The following is to address an alternative to the monolithic slab detail for the accessory building at 795 River Rd.

CONCRETE BASE RAIL ANCHORAGE

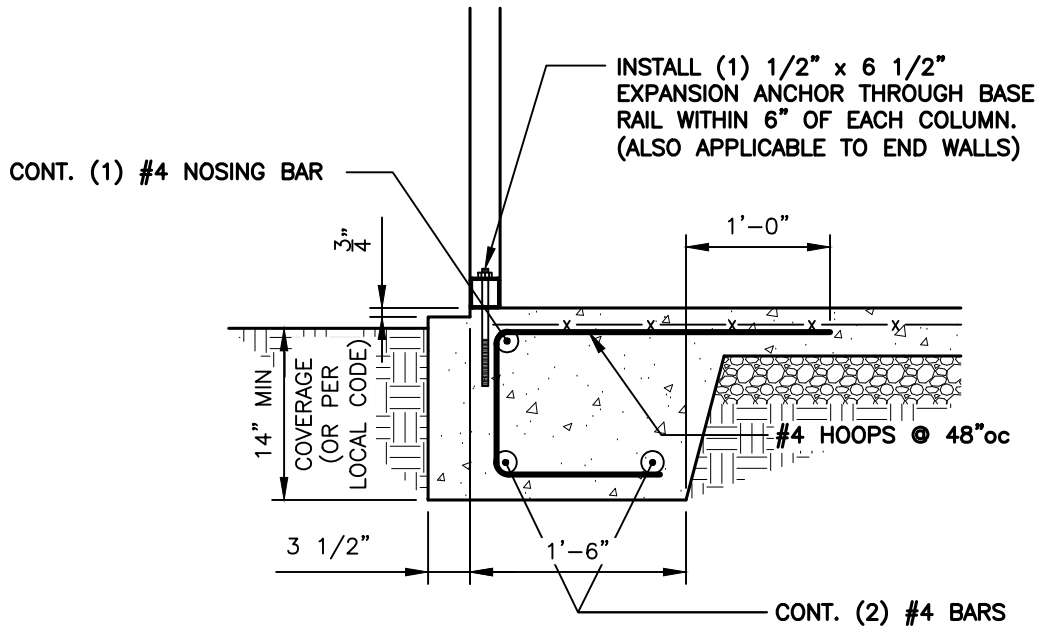
The original "Base Rail Anchorage" detail calls for #4 hoops at 48" O.C. with a nosing bar. An alternative Turn-down Slab detail is recommended and is adequate for construction in 115-120 MPH exposure B conditions. All calculations are based on an assumed minimum soil bearing capacity of 2000 PSF and a minimum concrete strength of 3000 PSI. See below:
